Demolition of 1 No. dwelling & erection of 4 No. dwellings. This application affects the character & appearance of the Station Road, East Preston Conservation Area.

St. Marys Close Hurst Road Rustington

Thank you for your internet representation made on 10th May 2017 which has been recorded as '**an objection**' with the comments as follows:

Drg No: 151117_SS-01 Rev: D

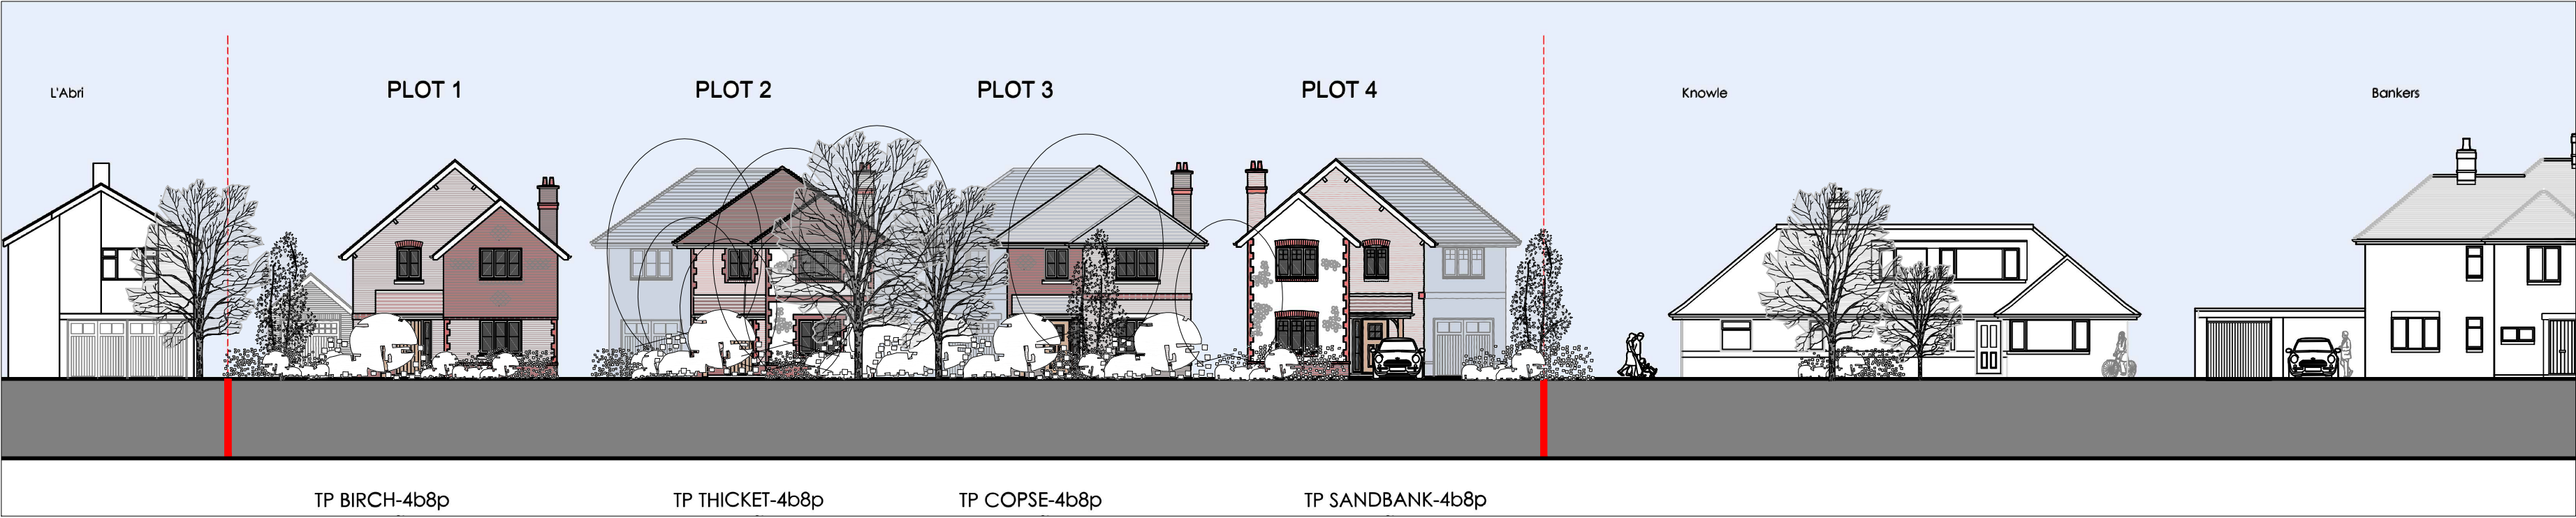
Only 2 designs of houses are proposed and there will be 2 of each type. Compared with the rest of Hurst Road they will all look very similar, whereas in the rest of Hurst Road all houses have a unique design. Therefore, the proposed houses will be out of character with the rest of the road and will seriously detract from the current 'street scene'.

The developer has attempted to make the 4 houses look 'unique' by cladding the frontages with various materials. But 'inlaying' frontages only puts a superficial veneer on houses that will still appear very similar compared with the genuinely unique elevations of other houses in the road.

The developer plans to put 2 garage blocks in front of the building line. There is no precedent in the road for this and this will again be out of character with the rest of the road and spoil the street scene.
